# ***City of Albuquerque***

May 6, 2004

**Re: Paika Shopping Center**  
**6522 Central Ave. SE**  
**Approval Of Temporary Certificate of Occupancy (C.O.)**  
**Engineer's Stamp dated 05/03/2004 (K-18/D088)**  
**Certification dated 04/15/03**

C2

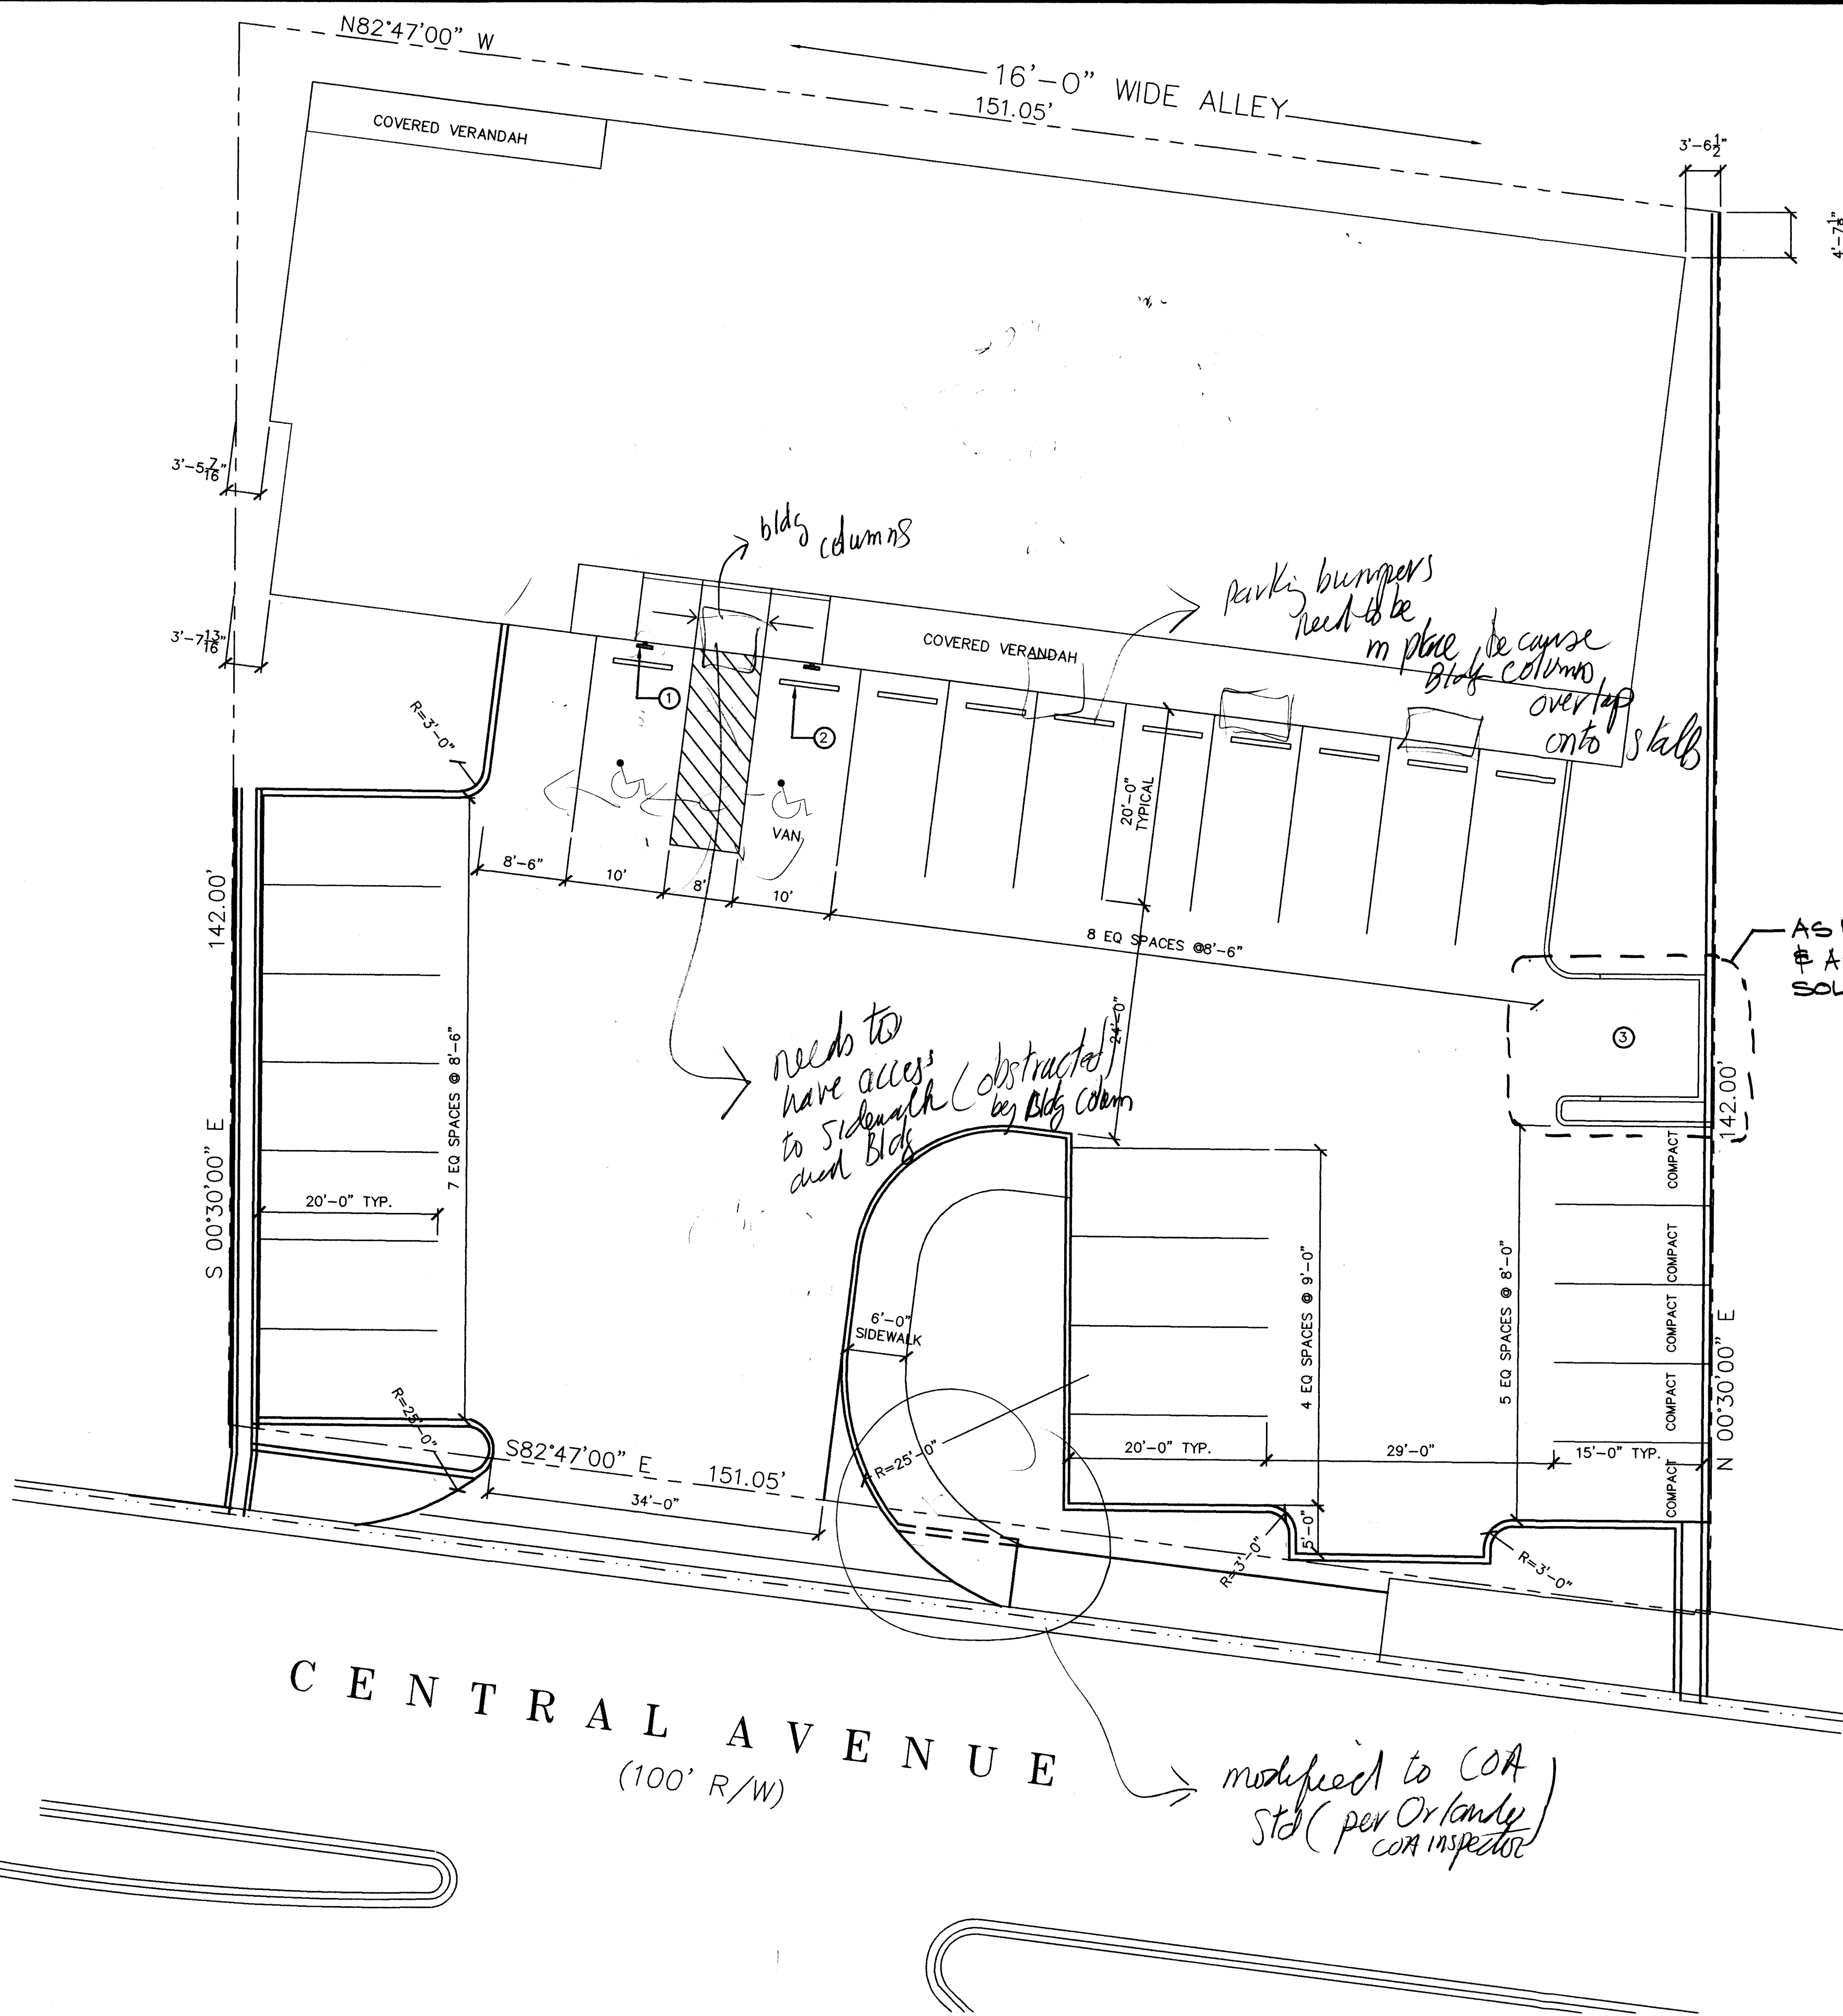
A Temporary C.O. has been issued for training and stocking only. Upon resolution of the SO-19 and other numerous exceptions, please resubmit an updated certification.

Upon resolution of SO-19<sup>+</sup> <sup>minor</sup> other exceptions acceptance,  
please resubmit an updated Cert.

PAIKA PLAZA SITE PLAN  
SCALE : 1" = 10'-0"

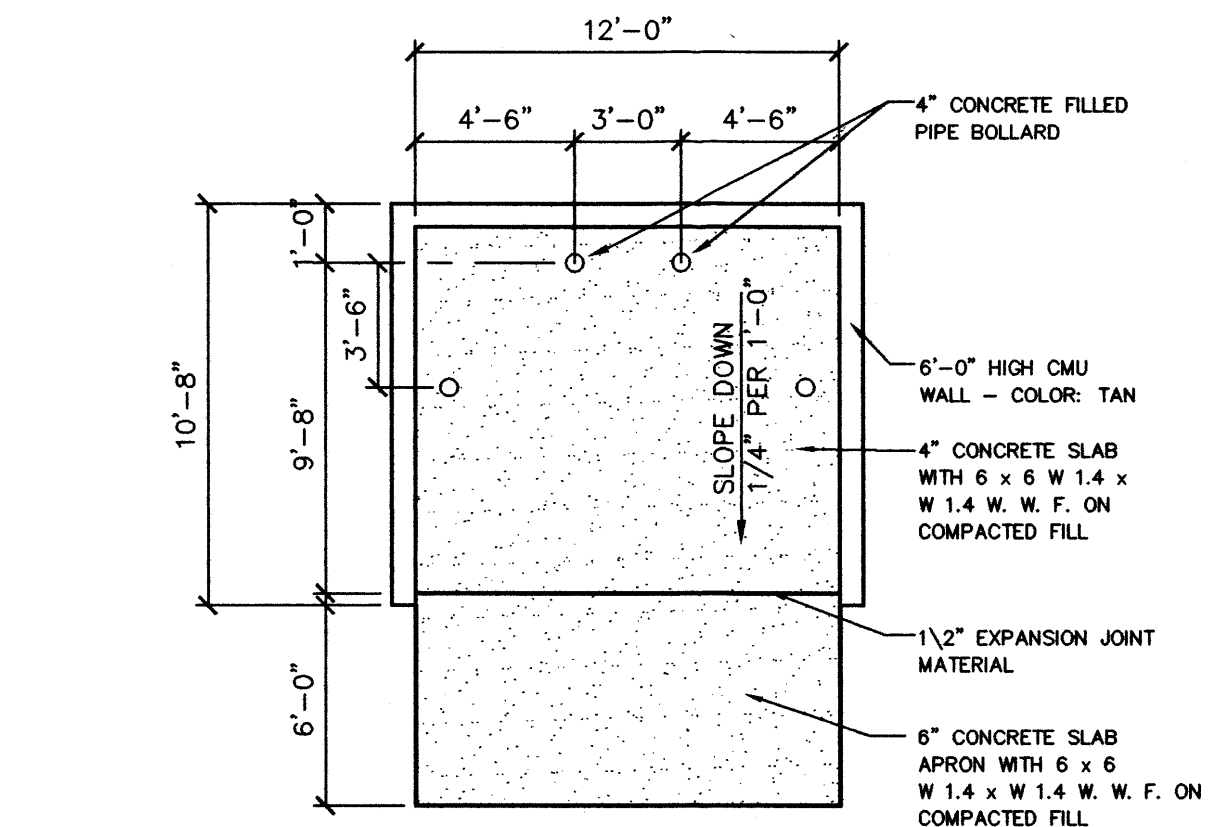
A Temporary C.O. has been issued allowing the outstanding wheel chair ramp (west ramp at entrance needs to be modified to reflect City Standards), van accessible stall needs to have access to sidewalk and building (obstructed by building column) ,and parking bumpers need to be provided (per approved site plan) issues to be completed within this time period. When these remaining issues have been fully completed, are in substantial compliance, and a final Certification for Transportation has been resubmitted to the City's Hydrology office for approval, a Permanent C.O. will be issued.
